**M4 (JUNCTIONS 3 TO 12) (SMART MOTORWAY) DEVELOPMENT CONSENT
ORDER APPLICATION**

TR010019

Written Summary of Second Issue Specific Hearing Dealing With Compulsory Acquisition

Date: 12 February 2016

Drawing file: TR010019 / TR010019-003601-Side Roads Plans Sheet 9.pdf

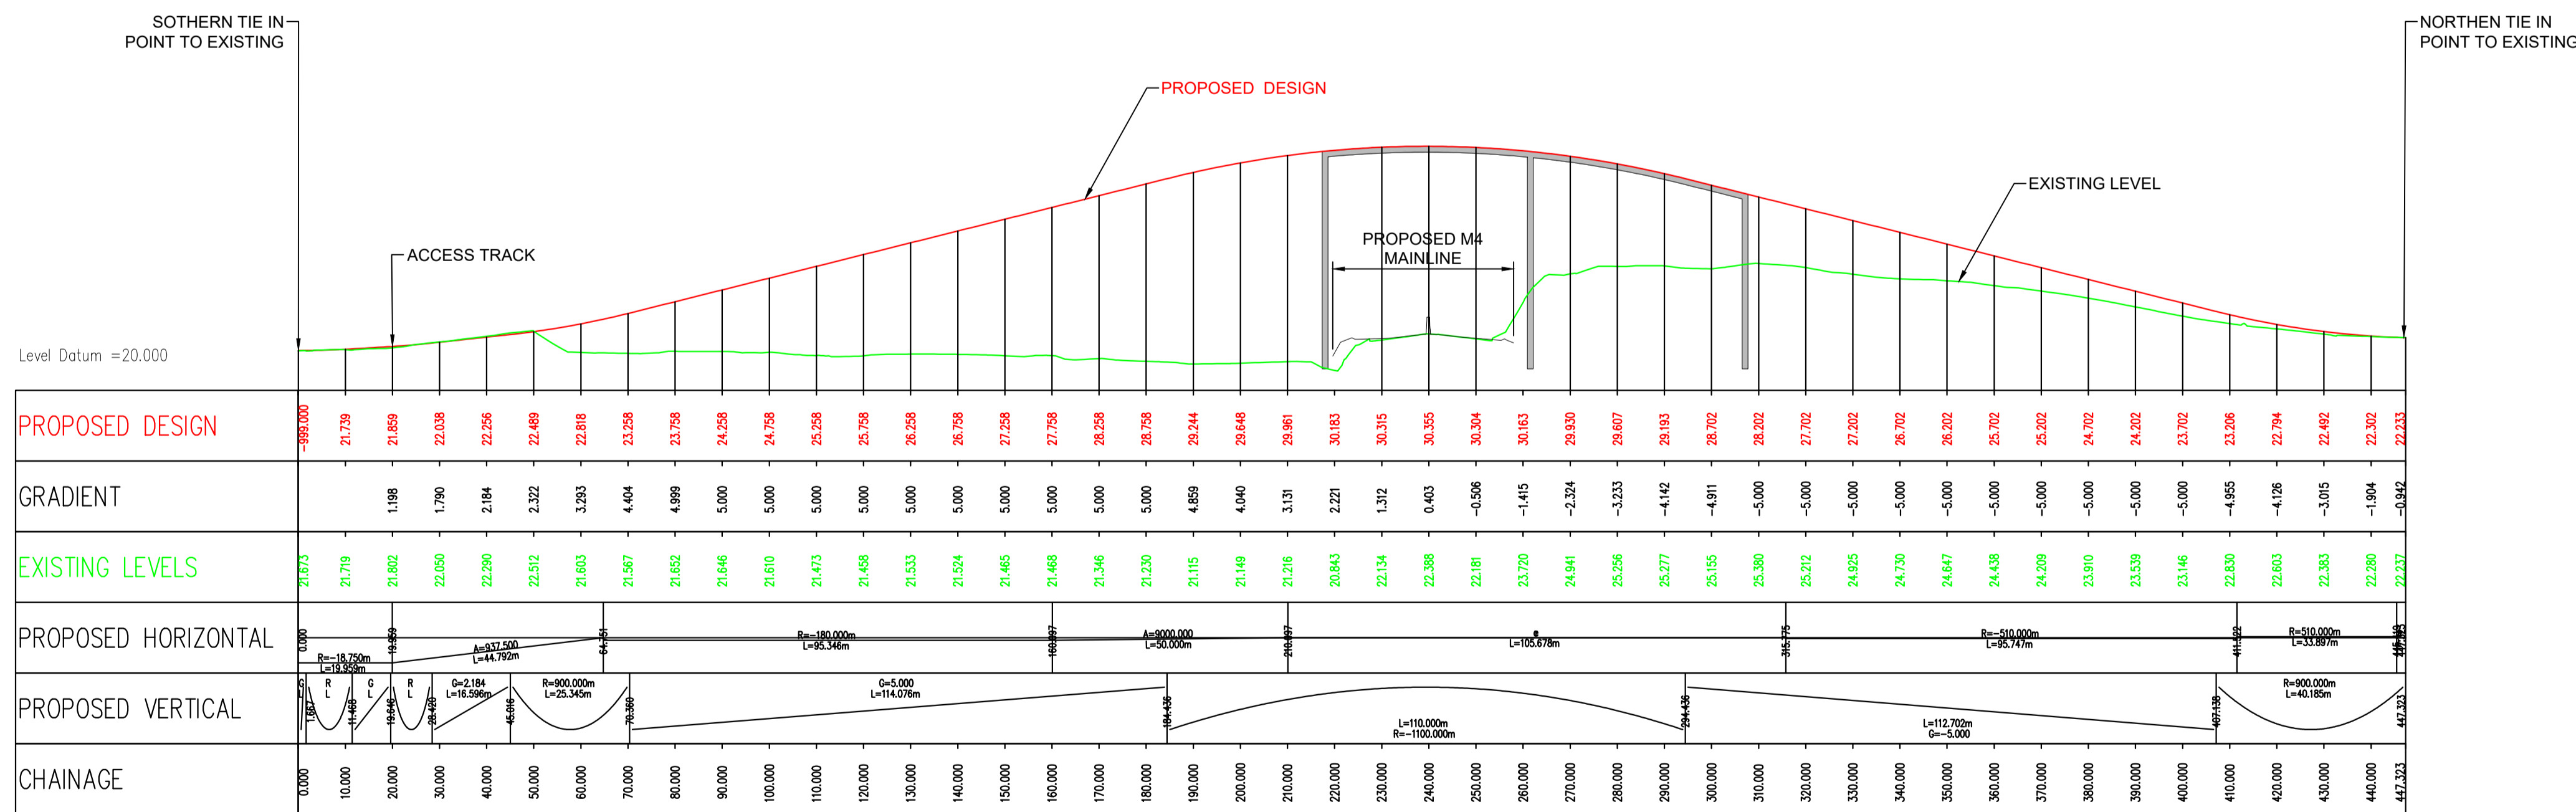
- 4.1 *Craig Broadfoot on behalf of TW stated that the main issue is to ensure access to the major sewage treatment works. TW's principal concern is a lack of assurances relating to access, on which TW would like clarity in the protective provisions. TW explained that the protective provisions currently state that Highways England will not prevent "reasonable" access, but TW stated that it cannot have long periods of interference. When asked by the Examining Authority if TW had a minimum amount of time in mind TW stated it required 24 hour access.*
- 4.2 *TW also suggested that Old Lane bridge could be used instead for access. However, TW were unaware of whether the bridge is structurally suitable for such access.*

- 4.7 Further, in considering the reasonableness of the requirements for access in this location, Highways England noted that the ES site road plan (sheet 9 of 13) shows that this is an offline bridge replacement. The new bridge will be built and opened before the old bridge is closed and removed. There should therefore be a bridge open at all times at this location, apart from short durations to enable tie in works. However, it is not possible at this stage of the design process to provide the sort of detail that TW has requested in relation to the exact timing of the works, and the dates and times of any interruption that may be required. That information will be provided to TW on the basis of the requirement to provide 56 days' notice to TW, as currently provided for in the protective provisions.
